DEVELOPMENT REVIEW BOARD  
SUPPLEMENTAL SUBMITTAL

PROJECT NO. PR-2020-004820

Application No. SI-2020-001468

**Re:** Hotel Circle Ramada Apartment Conversion DRB Update (PR-2020-004820)

B1 SITE - TYP. FLARED ADA CURB CUT
1/4" = 1'-0"

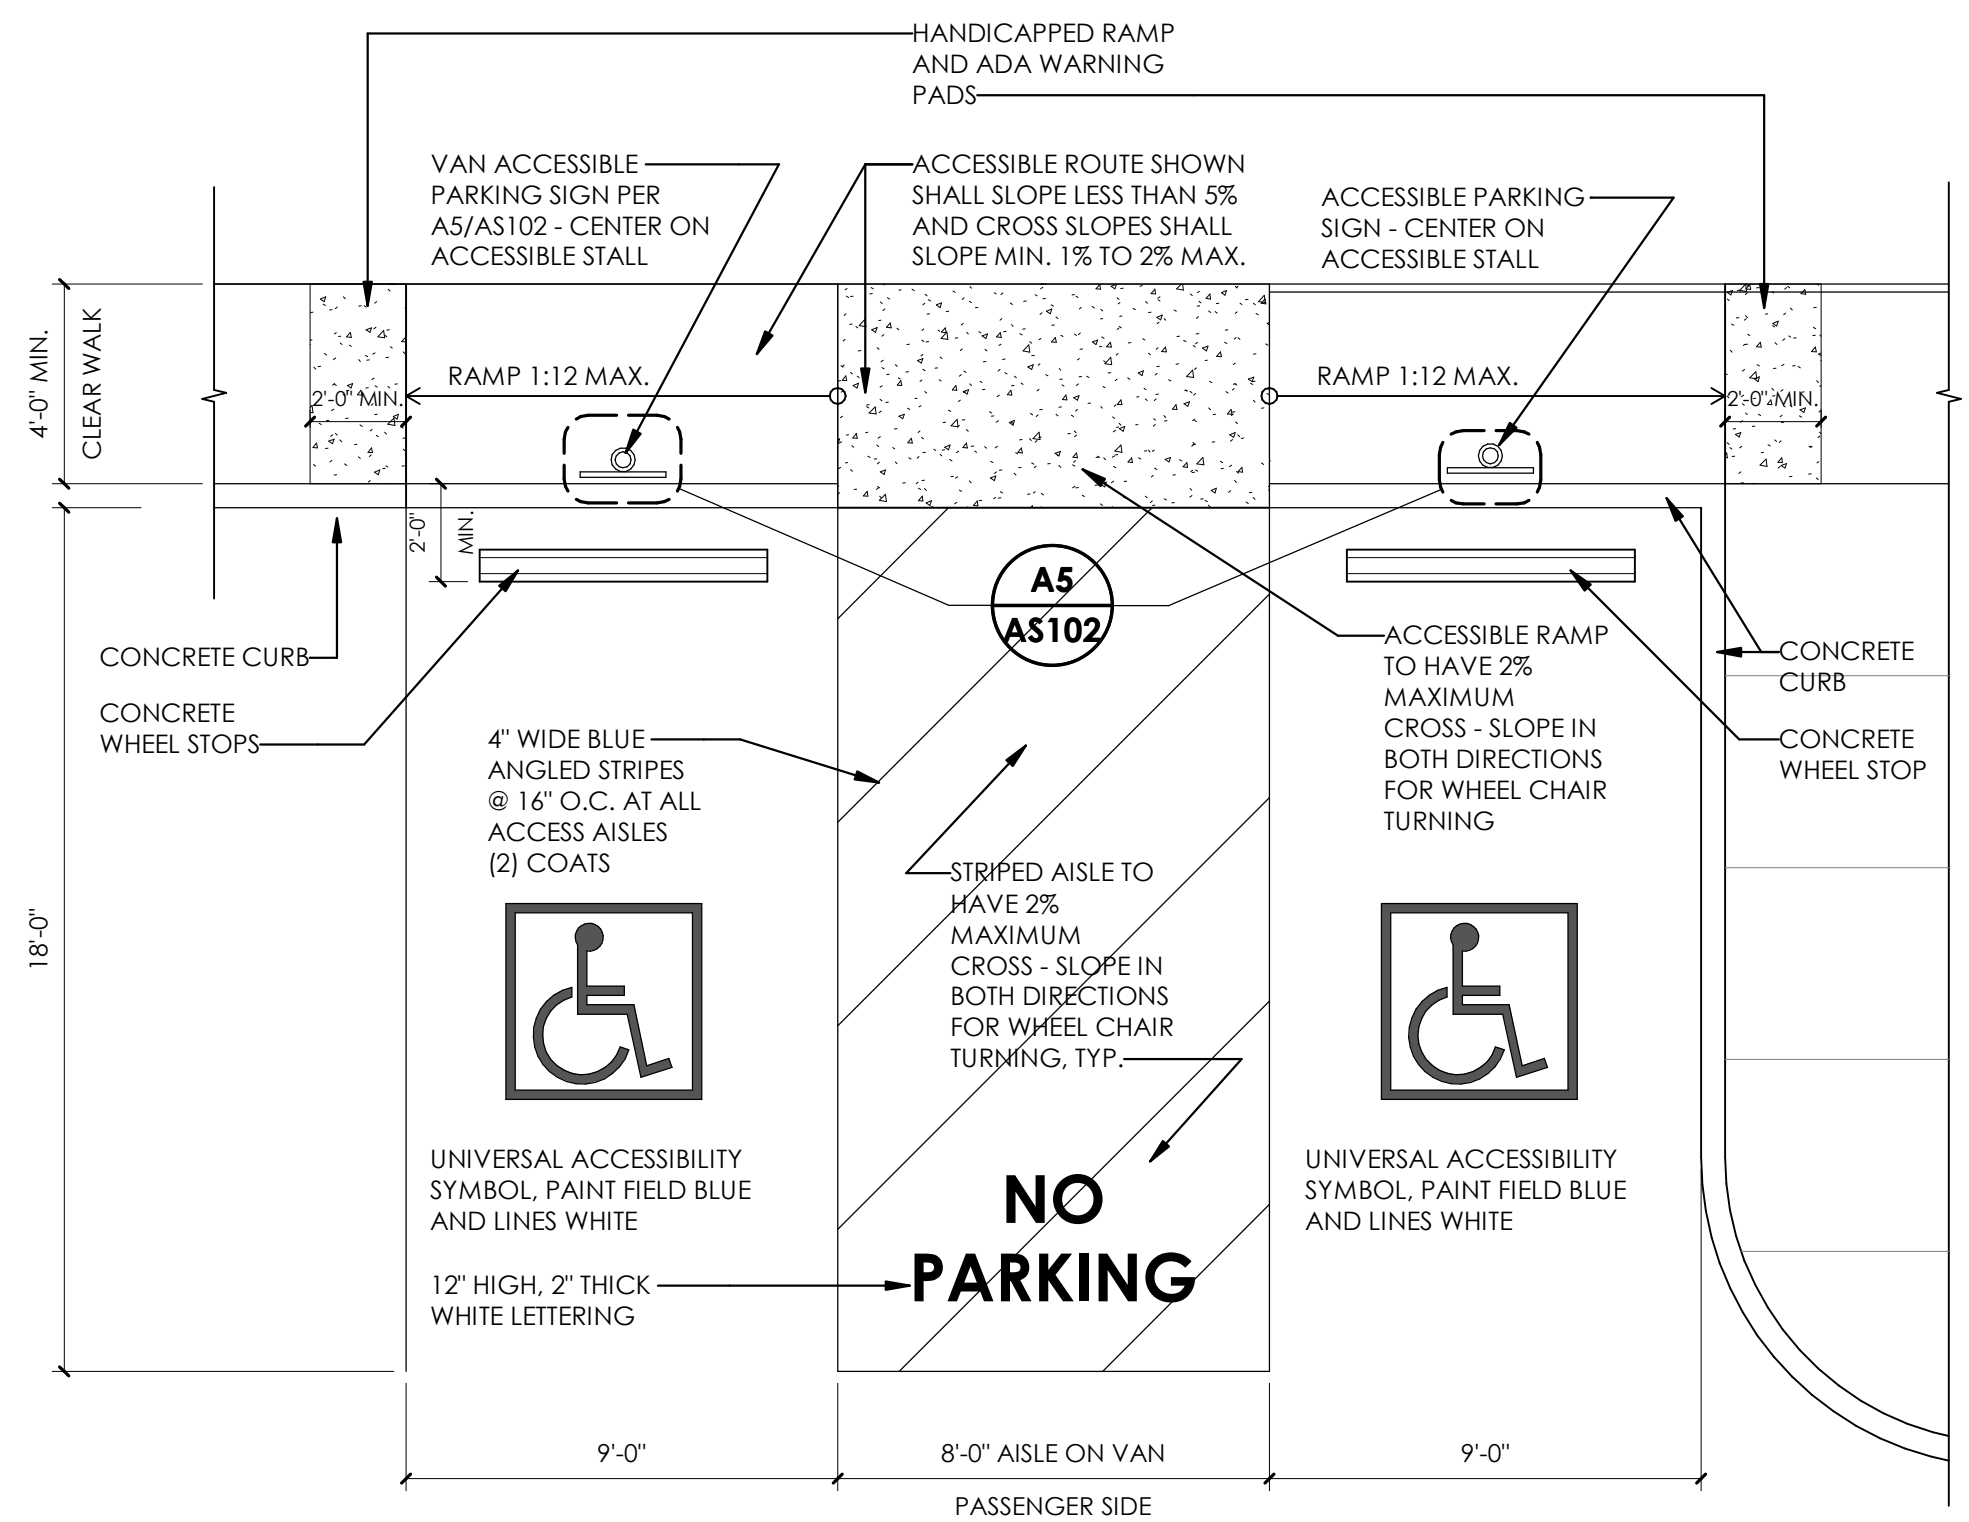
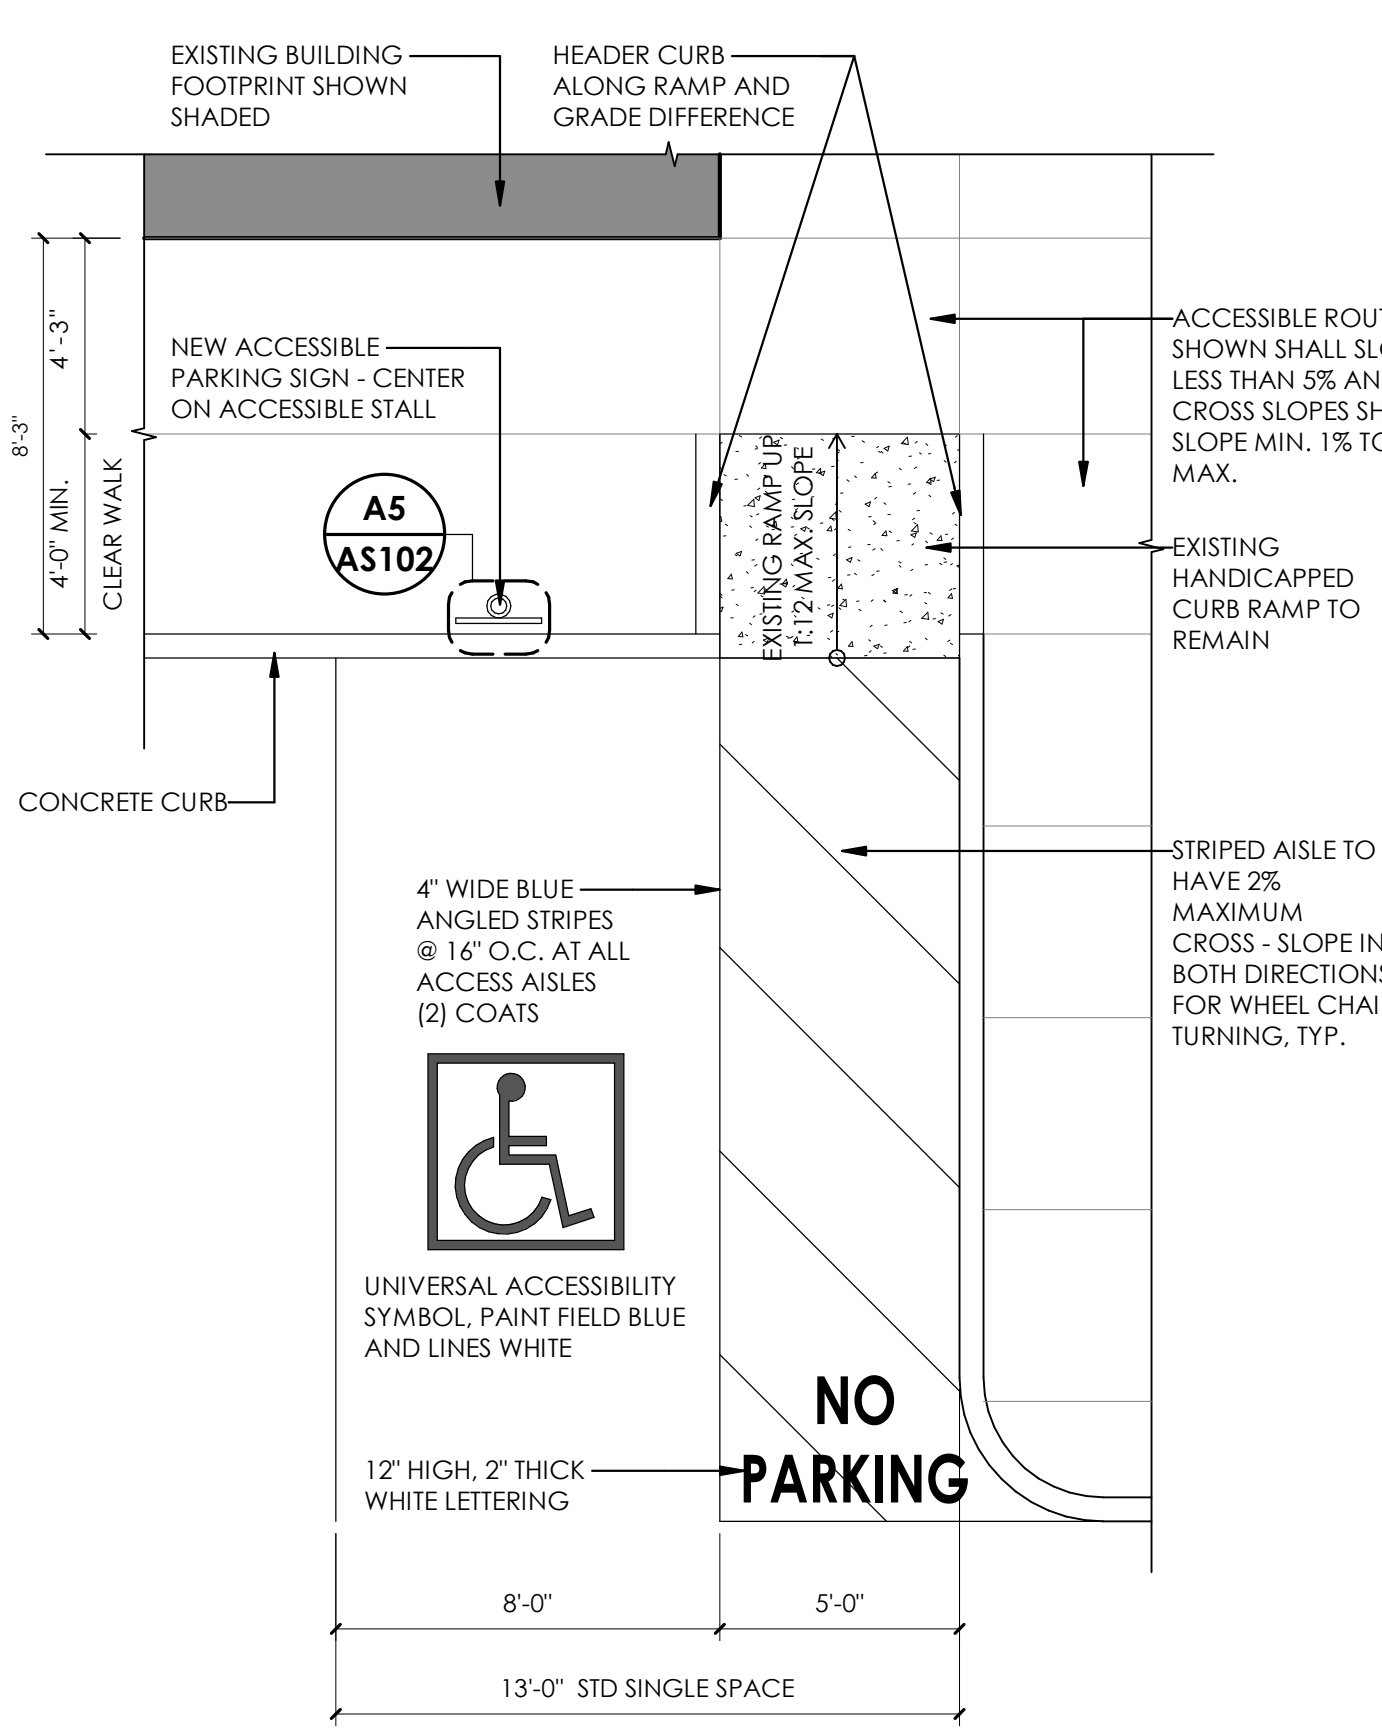
9. On the detail for the handicapped ramp that is perpendicular to the parking lot, show a minimum 4-foot pathway at the top of the ramp for turning a wheelchair. (Detail B1)

- a. ***The details have been dimensioned and updated with greater detail, as requested.***
10. Include a copy of the shared access agreement if it is available as indicated.
